COMMUNITY DEVELOPMENT DEPARTMENT  
501 Delta Avenue ♦ Marysville, WA 98270 ♦ (360) 363-8000

September 26, 2023

Re: Kendall Auto Group Auto Storage Yard – *Technical Review 1*  
PA 23020

SHEET 51

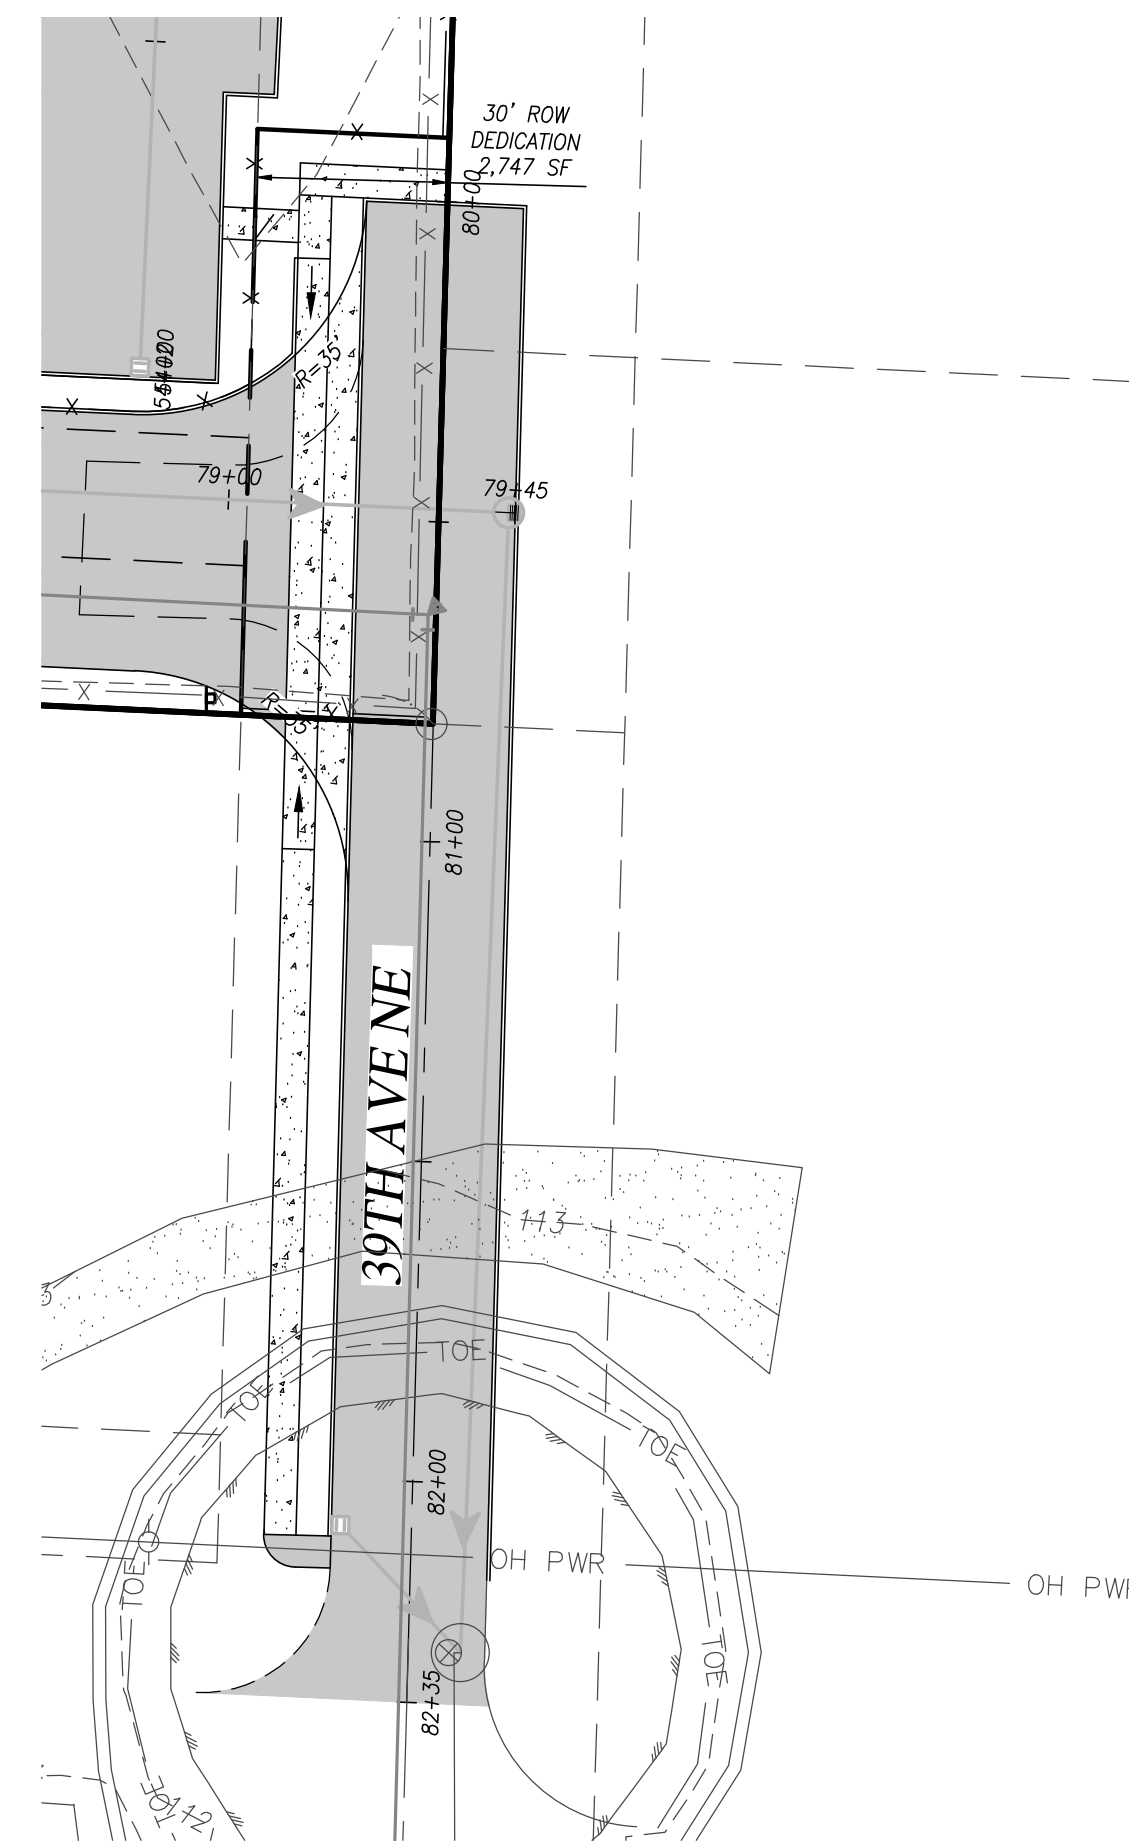
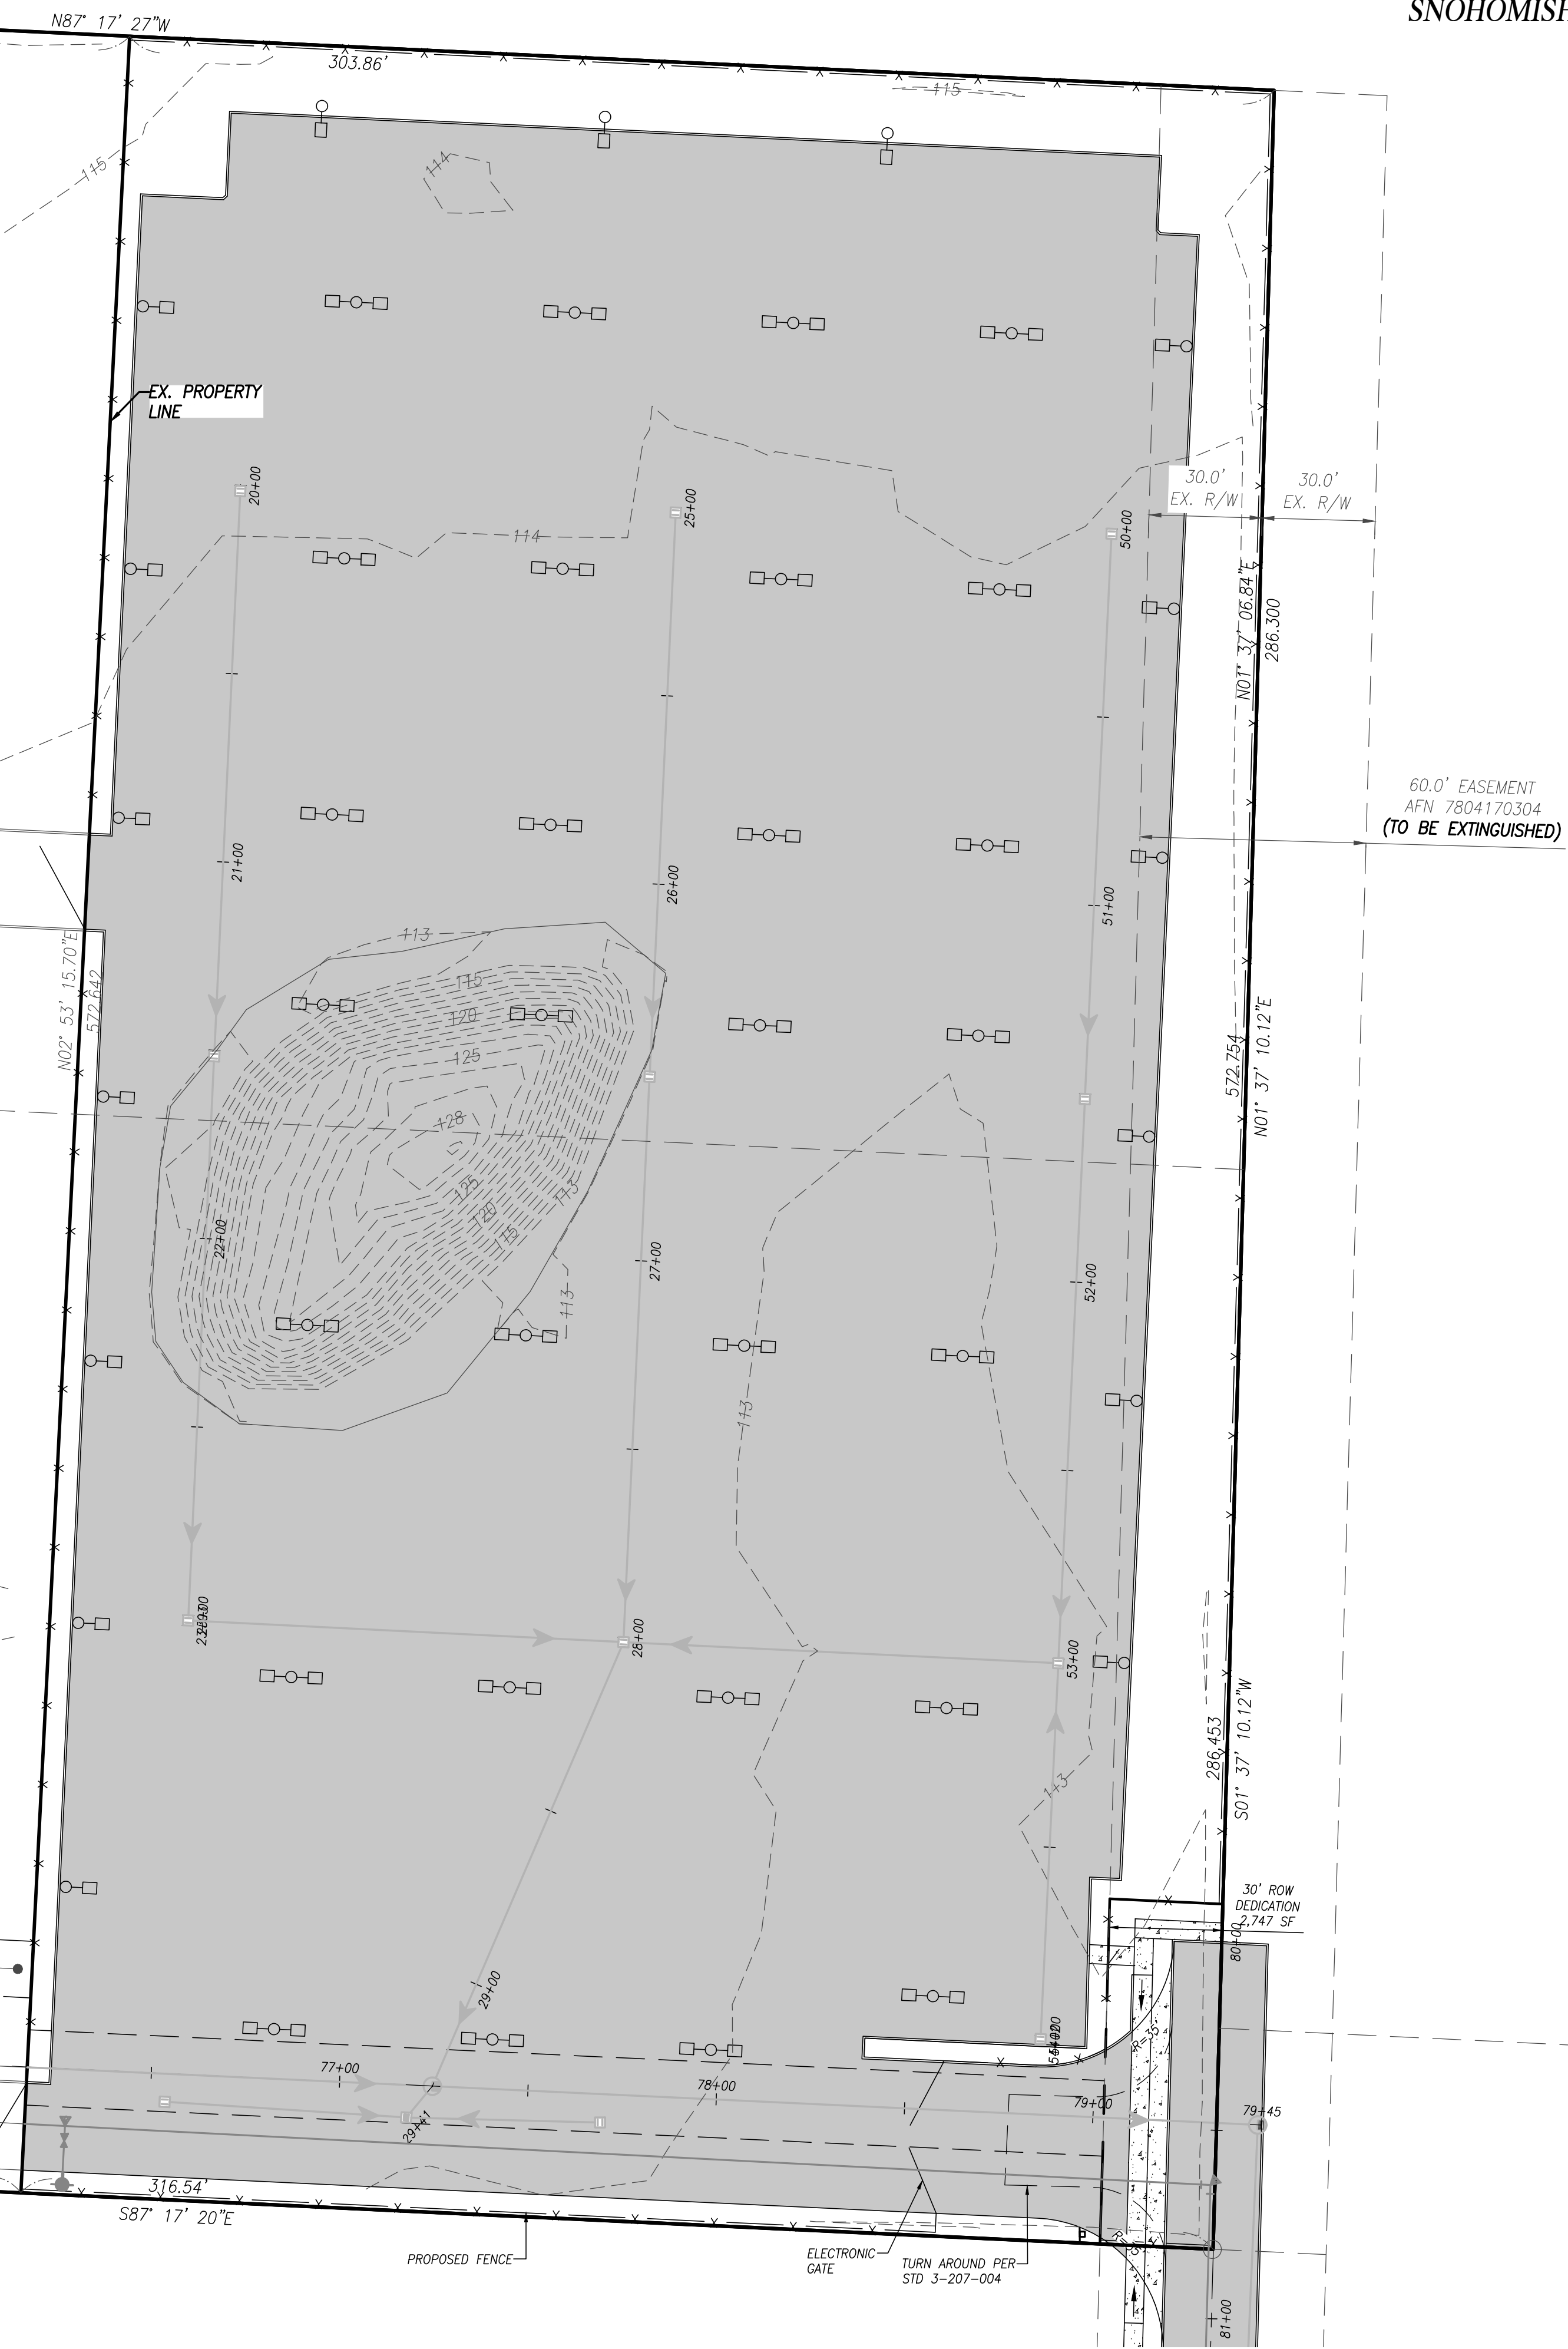
1. Provide File Number PA23020 on all future site, civil and landscape plan submittals.
2. Amend sheets S1 and C1.1 to depict all encumbrances outlined in Schedule B of the Title Report prepared by Chicago Title Insurance Company, dated July 25, 2023. If the encumbrances cannot be depicted then they will need to be referenced.
3. According to the Wetland & Stream Reconnaissance Report prepared by Wetland Resources, dated February 15, 2021, APN 31052800300100 & 31052800302200 have critical areas and associated buffers located on the city owned parcels within the 60' easement, recorded under AFN 7804170304. The applicant will be required to conduct a critical areas analysis to determine the extent of the critical areas, associated impacts and any mitigation measures for extending 39<sup>th</sup> Avenue NE in order to access the storage yard.
